**From:** Foster Ben  
**Sent:** 17 June 2021 15:50  
**To:** Development Control  
**Subject:** FW: Written Direction, 21/00913/FULL - 11 Malvern Avenue

**From:** Foster Ben  
**Sent:** 17 June 2021 15:50  
**To:** [REDACTED]  
**Subject:** Written Direction, 21/00913/FULL - 11 Malvern Avenue

Proposed Rear Elevation

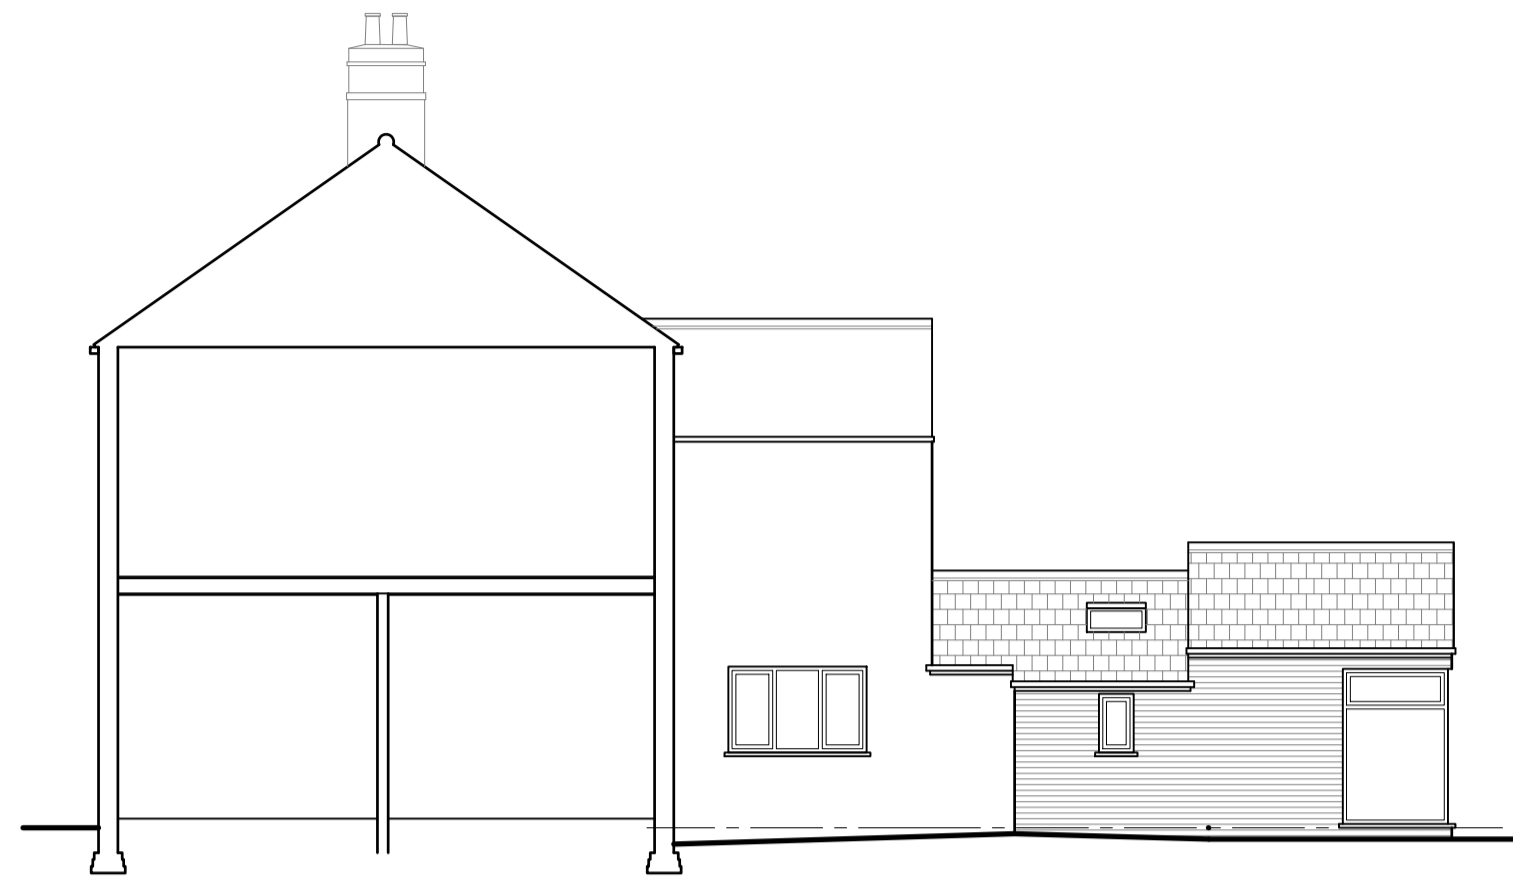
- **Please include overall height and eaves height on proposed plans**
